From: Sarah Fawdry [REDACTED]
Sent: 02 March 2023 15:55
To: Jessica Riches; David Easton
Cc: Chris Brake; Katie Martin; Martin Kempshall; Thomas Richards; Silvie Steiningerova
Subject: Bilsham Road, Yapton - Y/70/22/DOC and Y/34/22/DOC
Attachments: 2023 02 08 Y 70 22 DOC Drainage Response.pdf; D1956-13-200B Proposed Levels Layout.pdf; D1956-13-201B Proposed Levels Layout.pdf; D1956-13-202B Proposed Levels Layout.pdf; D1956-13-300B Proposed Permeable Paving Formation Levels.pdf; D1956-13-301B Proposed Permeable Paving Formation Levels.pdf; D1956-13-302B Proposed Permeable Paving Formation Levels.pdf

Having recently picked up comments on your online portal regarding Y/70/22/DOC (dated 8 February 2023; attached for ease), please find our responses to the outstanding queries as follows. For ease and completeness, I have followed on from the previous queries with our responses, our latest response is detailed in green.

TYPICAL HEADWALL SAFETY GRILL

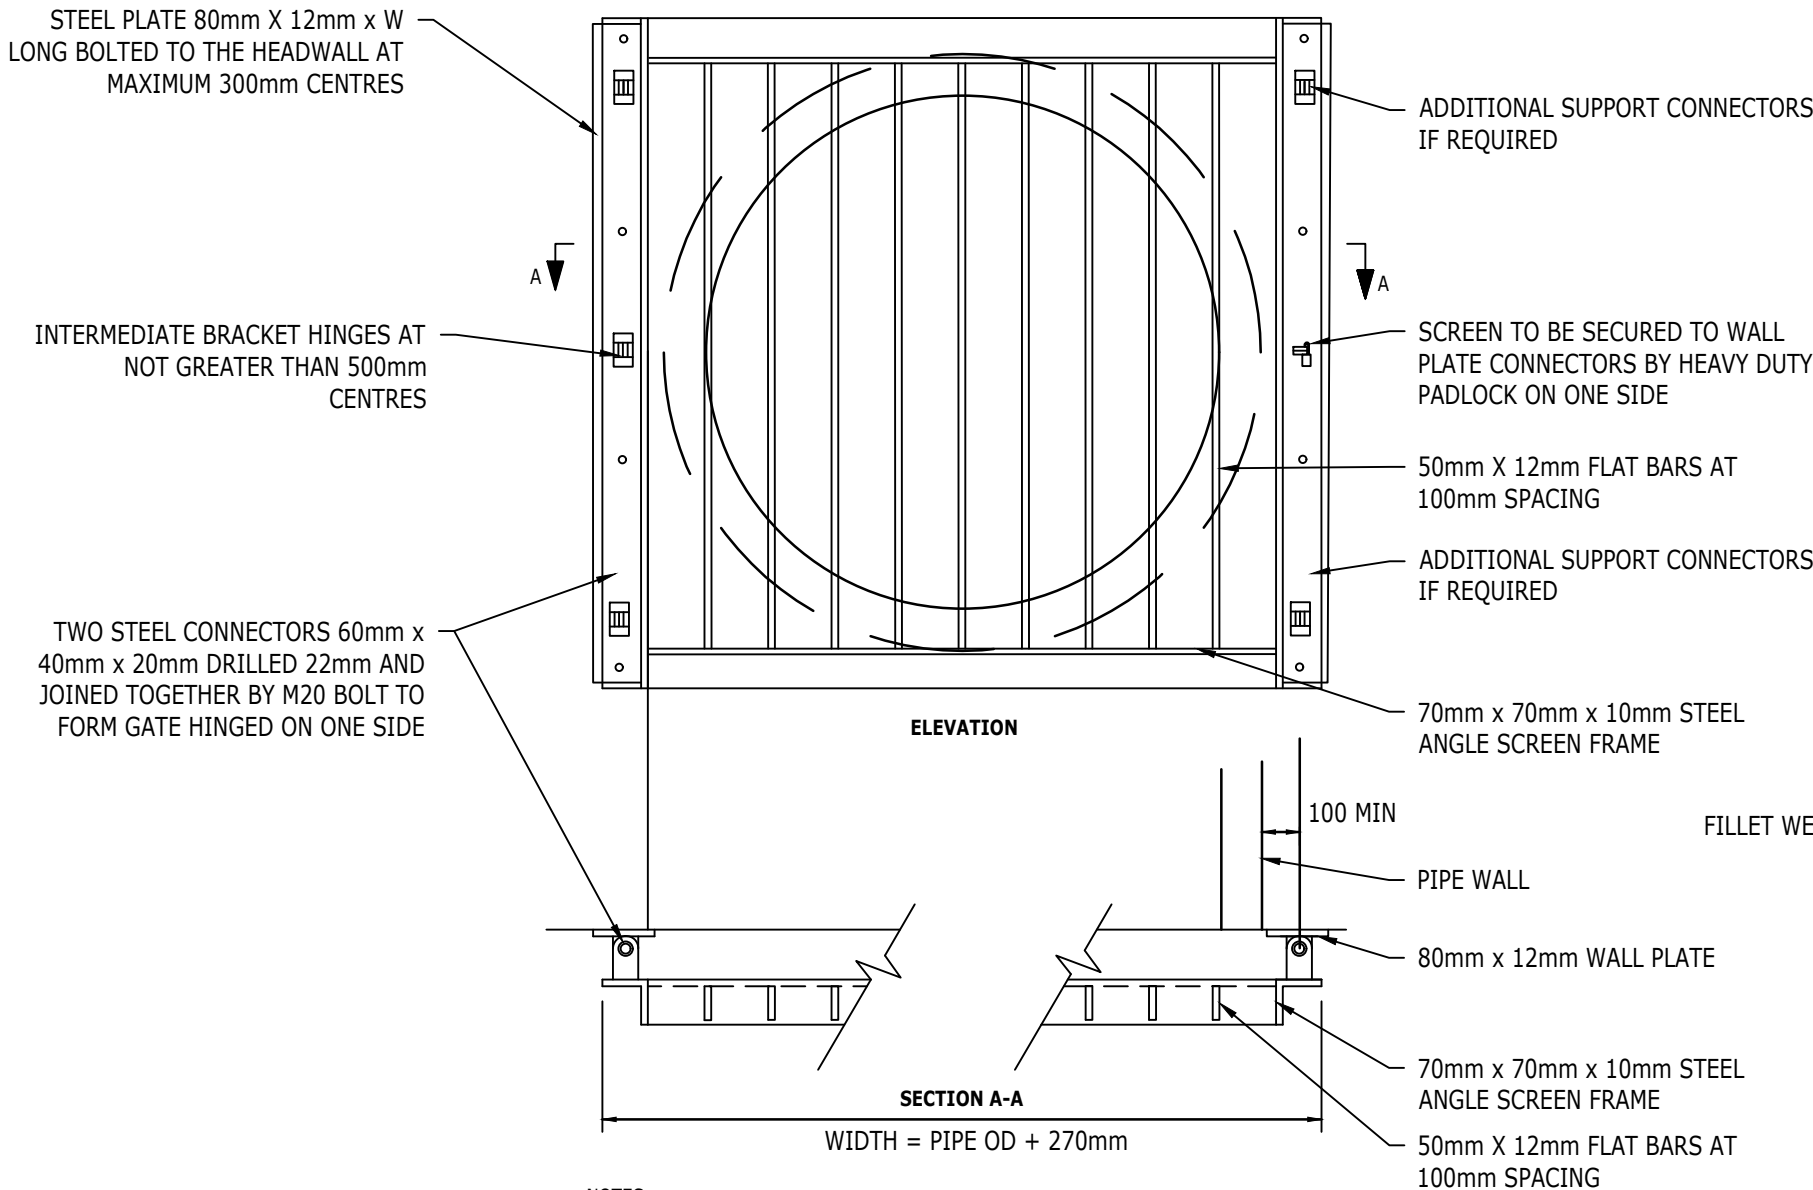
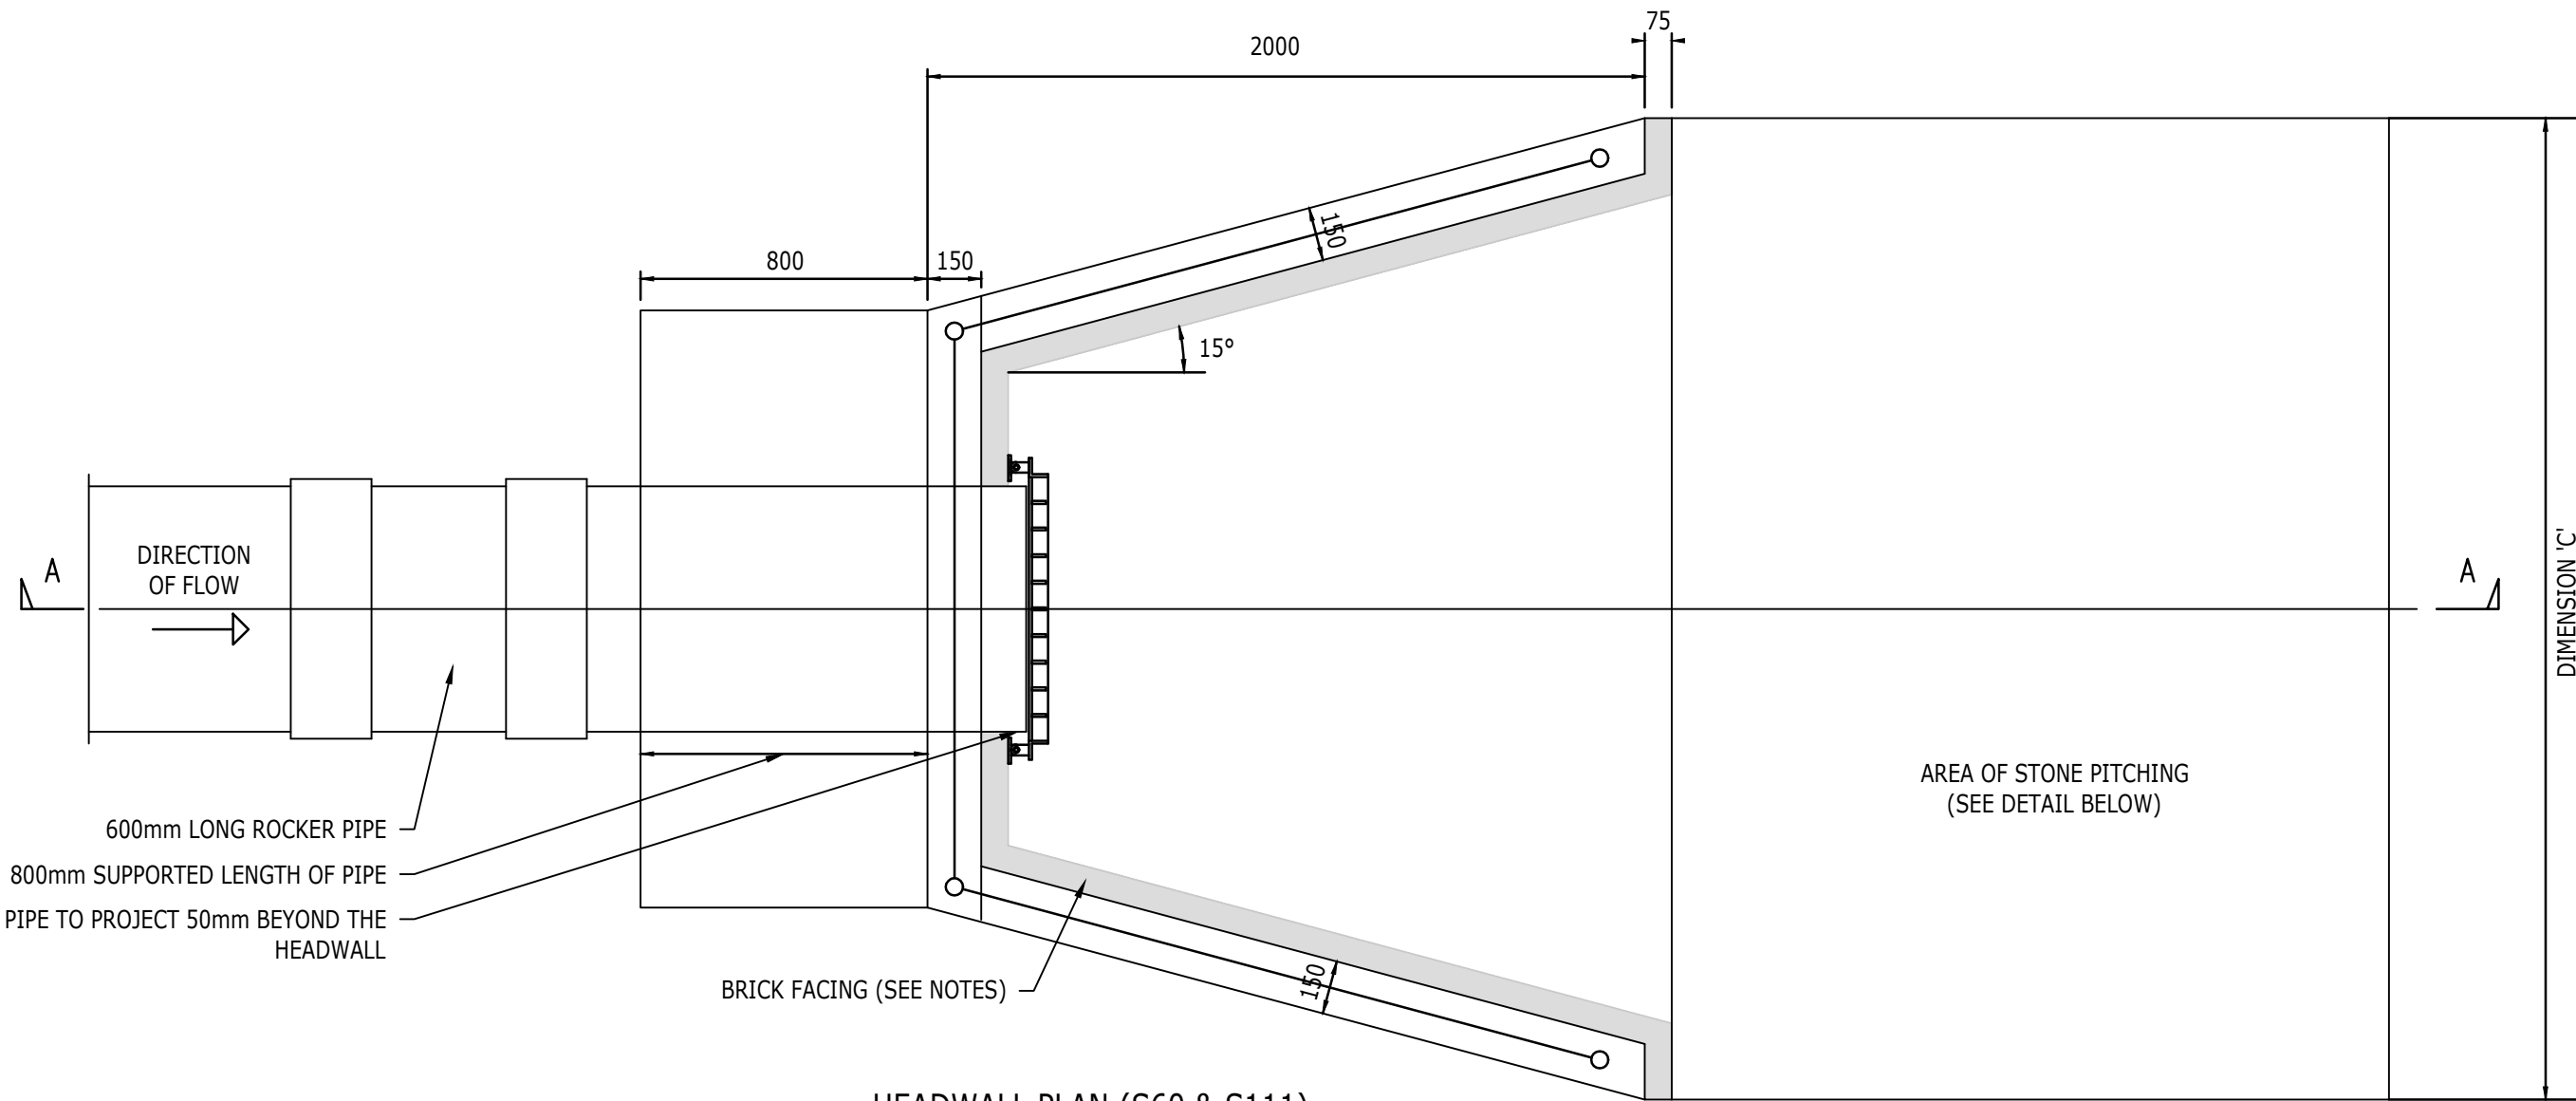
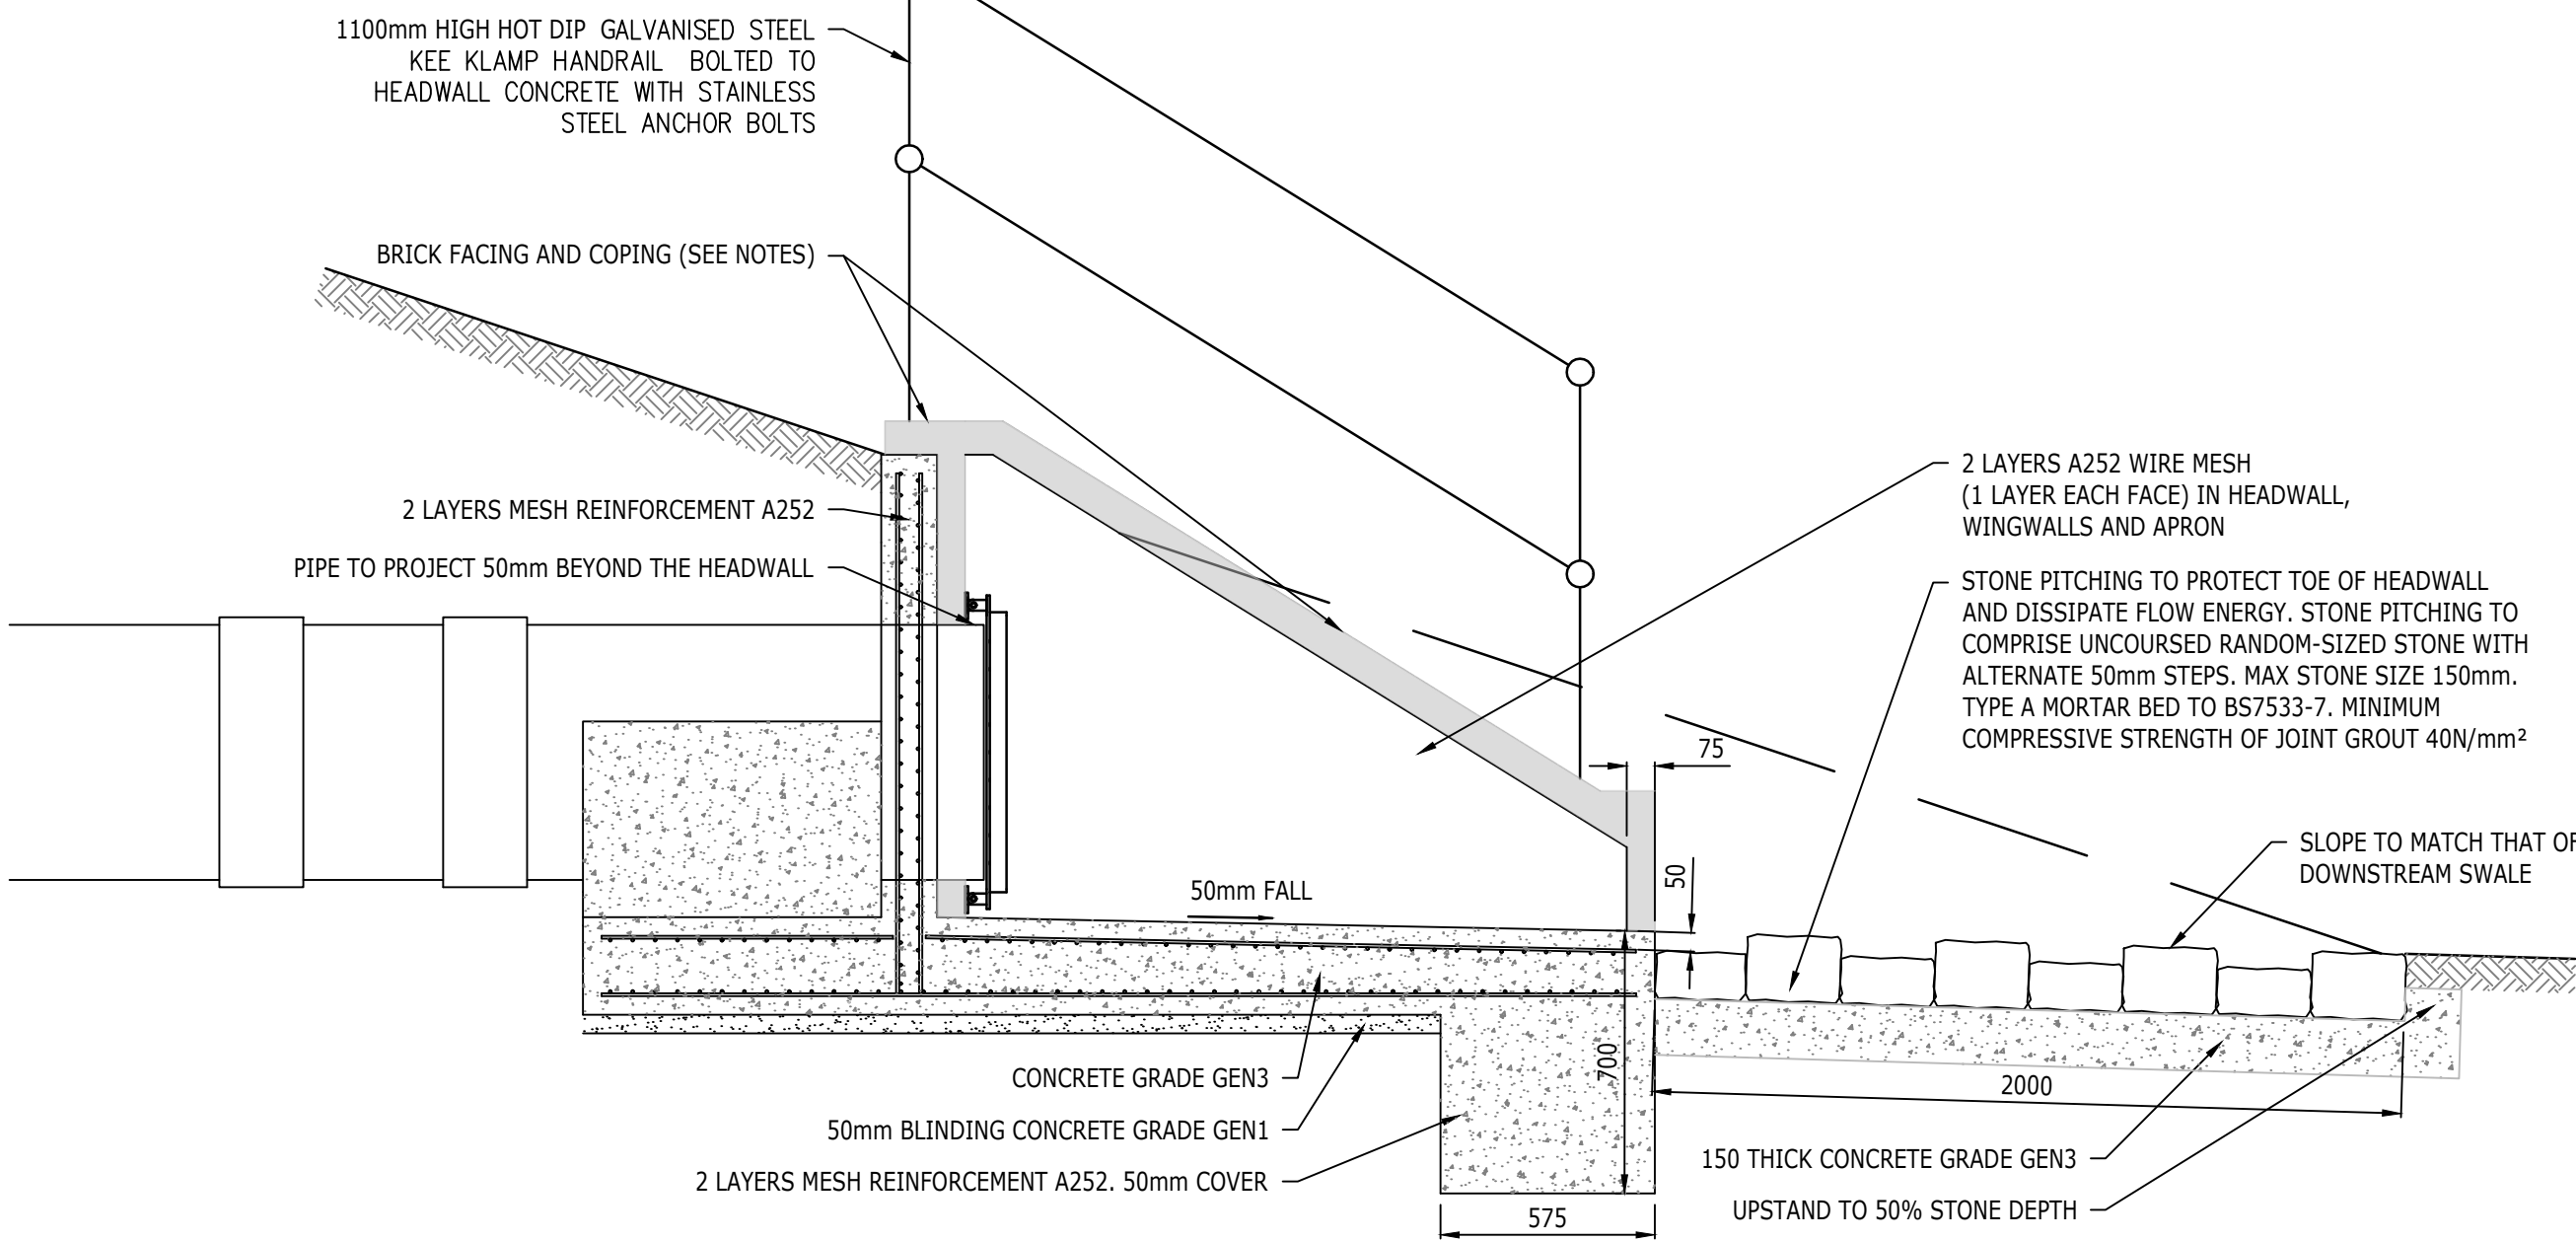
11. Please provide cranked grilles at a 45 degree angle. - Cranked grilles required on heads – S104 Construction details sheet 1 of 2 D1956-15-100 needs to be updated to suit ADC requirement. Pipe beddings details on this drawing are illegible in parts. Information needs to be clearly presented. We note that applicant's response that this is not "DSG compliant" however the drawings refer to Sewers for Adoption 7th Edition. As such the applicant needs to be clear which edition of Sewer for Adoption the adoptable drainage is being designed to. In addition they should confirm who the adopting authority will be as well as confirmation from the adopting authority on whether they will or will not accept cranked grilles. 08/02/2023- Whilst it is noted that the Technical Approval certificate has been provided for information, this doesn't clarify whether the adopting authority has considered a request to use cranked grilles. This needs to be confirmed by the adopting authority otherwise cranked grilles should be used TH: There is no provision in DCG for the use of cranked grilles, only grilles installed flat against the headwall. In addition, we consider that cranked grilles create a health and safety issue as they could encourage people to climb up on them up to a perch from which people could fall.
